From: [Bennett, Sophie](#)
To: [McAllister, Jo](#)
Cc: [Barrett, Julia I](#); [Setters, Chris M](#); [Murphy, Alexander N](#); [Woodhouse, Helen](#); [Klemperer, Bill](#); [Timothy, Jenny S](#); [Nic Wall](#); [Jo Manley](#)
Subject: RE: A303 Sparkford to Ilchester Dualling - Non-material amendment Hazlegrove House RPG
Attachments: [ATT00001.txt](#)

Subject: RE: A303 Sparkford to Ilchester Dualling - Non-material amendment Hazlegrove House
RPG

Thank you for sending the revised proposal through following the workshop. The proposed design changes are welcomed and are an improvement on the scheme submitted for the DCO.

Drawing Title: **WORKS PLANS REGULATION 5(2)(j) SHEET 1 OF 4**

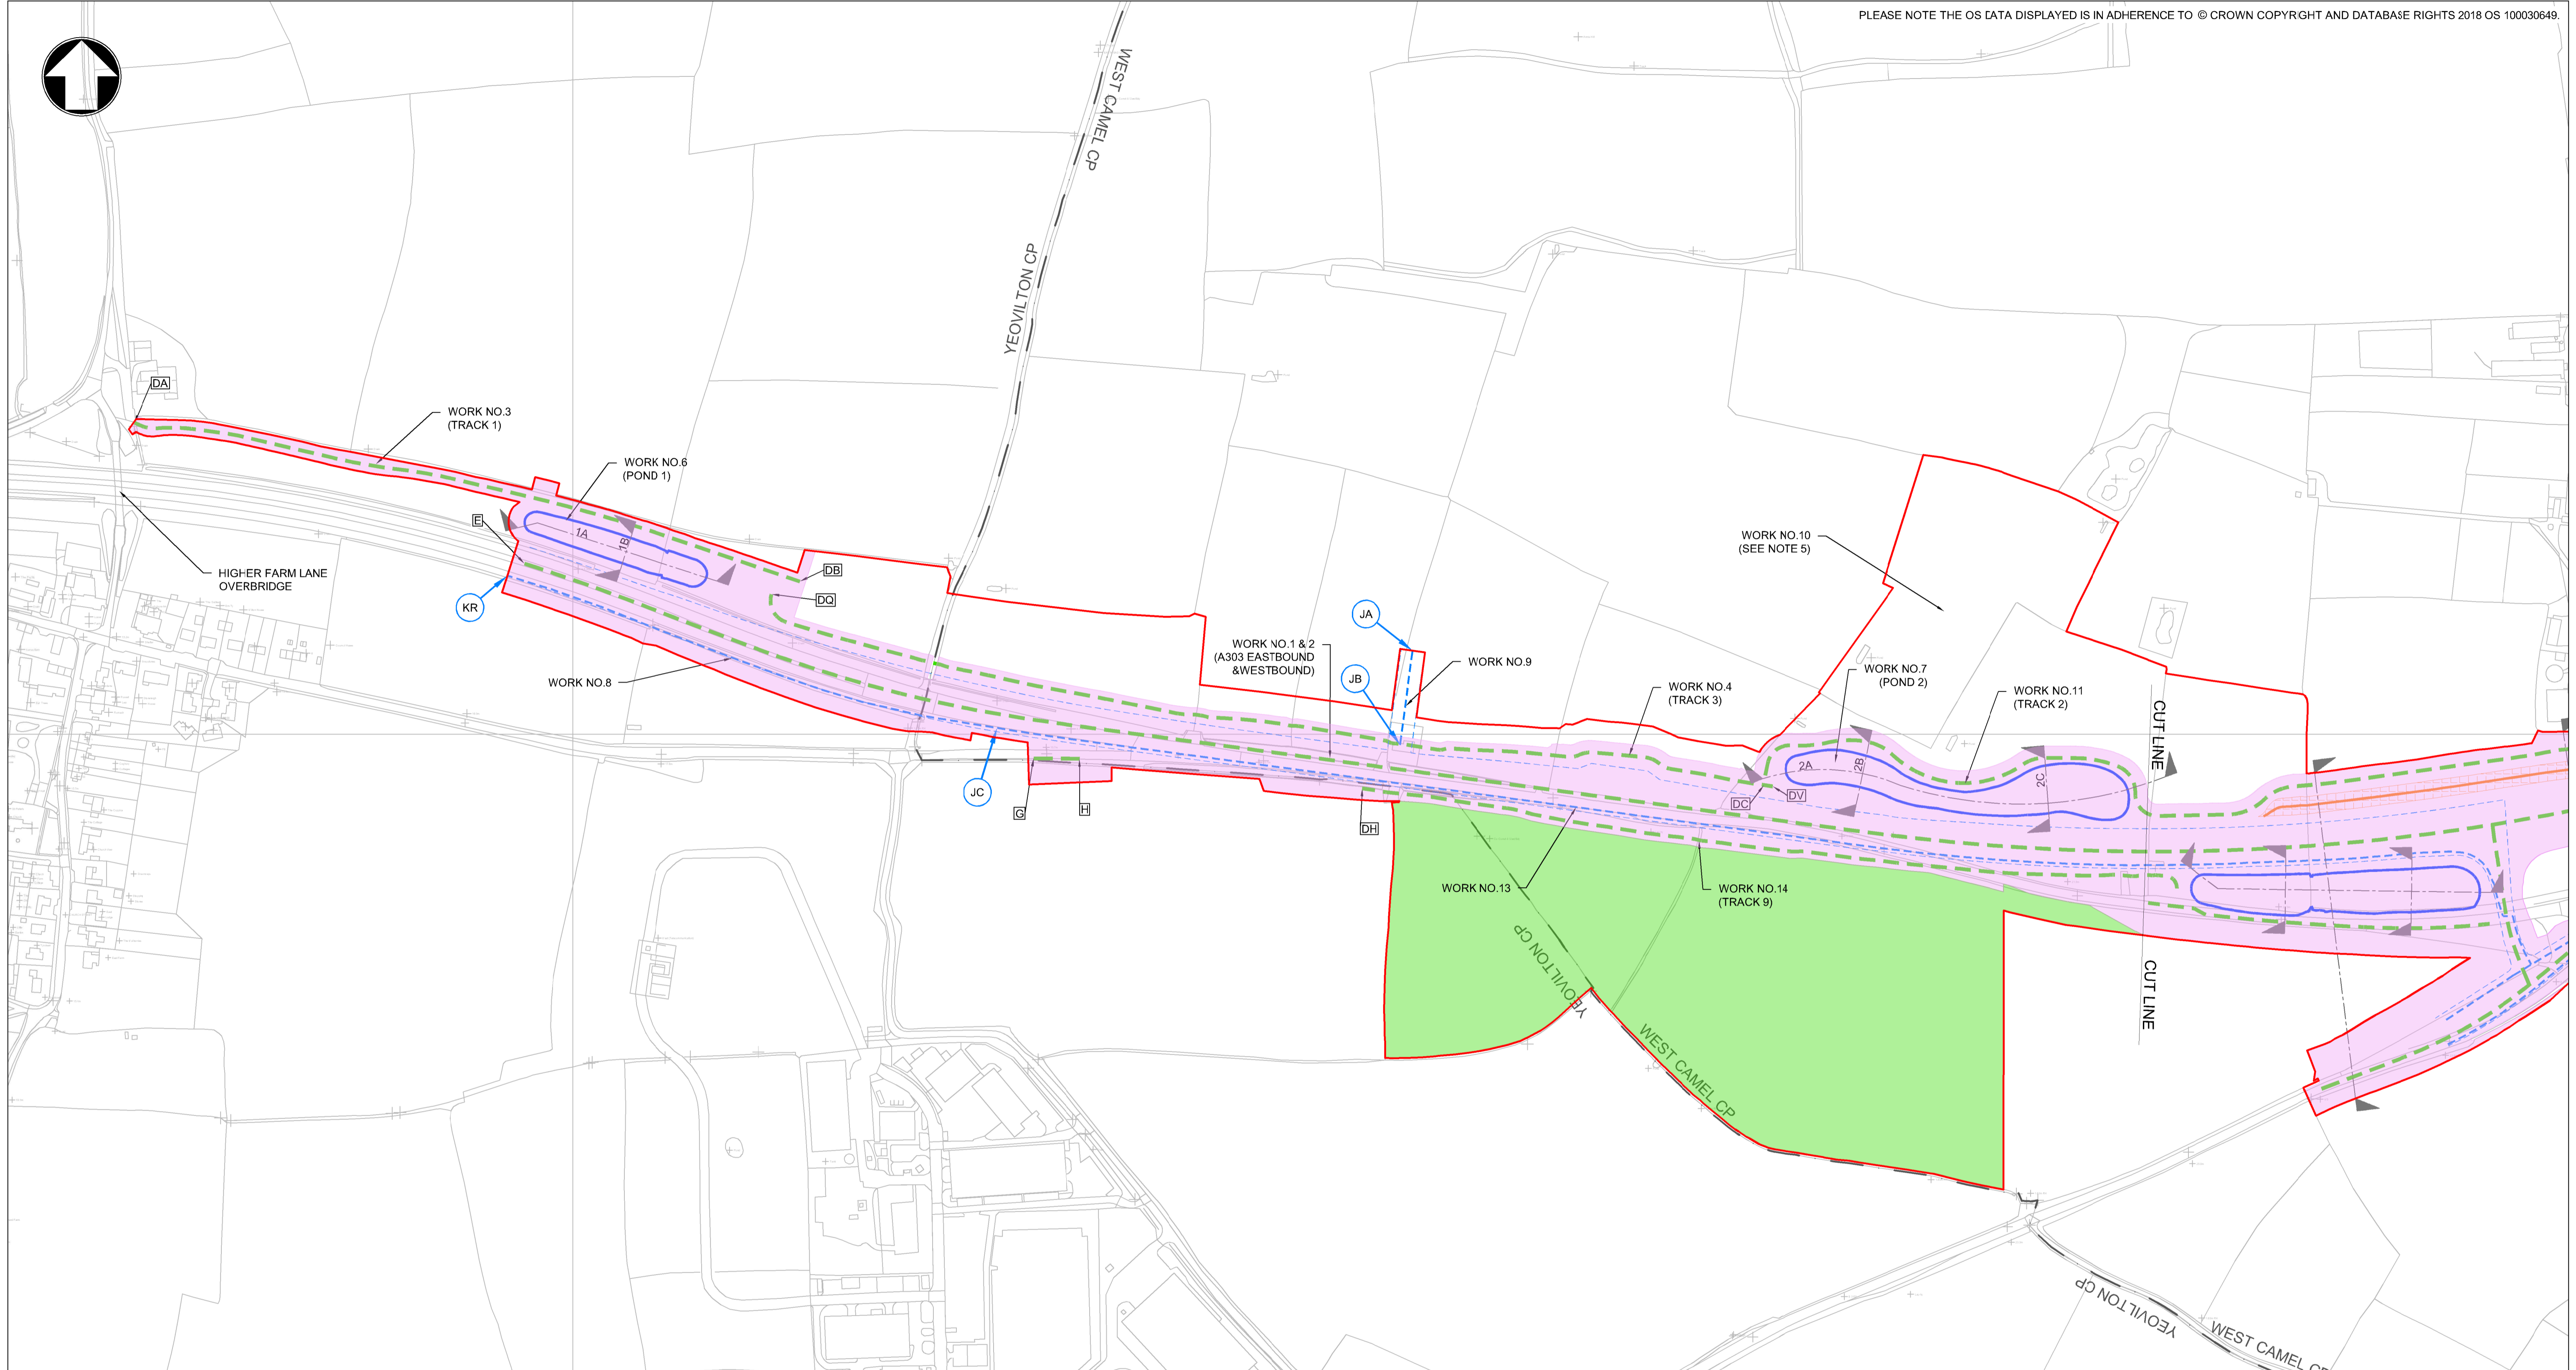
Although the physical impact of the pond moving westwards appears to be quite limited, ie. in terms of reducing its physical/ visual presence, we welcome the following changes:

- the realignment and change of surface to the maintenance track to its reduce visual impact;
- the change in fence type to estate railings to better respond to the parkland setting;

- Movement of the fence line west increasing the area of open parkland to the east - As you are aware in the workshop we discussed the option of keeping the fence in its existing position, demarcated the original drive into the park, however, we consider the increase in open parkland to offset the presence of the pond to be beneficial in improving the entrance approach along the drive;

- The realignment of the drive further north into the park, and the retention of the oak tree (we assume no. 15 as identified in the AIA – Appendix 7.3 of the ES). The latter will help towards mitigating the loss of the veteran oak (tree 12) on the site of Bund 6;

- Additional woodland south west of the pond to frame views on arrival into the park, and partially screen views of the access track.

With regard to the screening of the environmental barrier adjacent to Bund 7, it is difficult to assess the impact that the additional planting will have, given the difference in height between the planting level and road level. Our comments are therefore limited on this mitigation measure.

- Pond 5 has been moved slightly south and west further into the corner of the RPG;
- The maintenance track for Pond 5 has been realigned to follow the western perimeter of the pond and is proposed as a re-enforced grass;
- Accordingly the eastern perimeter fence of the pond has been moved westwards by approximately 20 metres;
- Estate style fencing is now proposed to enhance the appearance of this area of the RPG;
- Hazlegrove School Access has been moved approximately 20m northwards and now avoids the veteran tree;
- Additional woodland planting has been provided to the south-west of Pond 5 so that the arrival point is an emergence from woodland with views to Hazlegrove House over the pond; and
- Additional screening planting has been provided in front of Bund 7 (such as in the form of semi-mature trees) in order to screen the environmental barrier.

We have not been able to use the private access to the north west of the pond location as this is outside the red line and using this would not be classed as a non-material amendment. With regard to the environmental barrier again a redesign of the drainage would not be classed as a non-material change, and as such we are proposing using a mature screen in year 1 to screen the barrier.
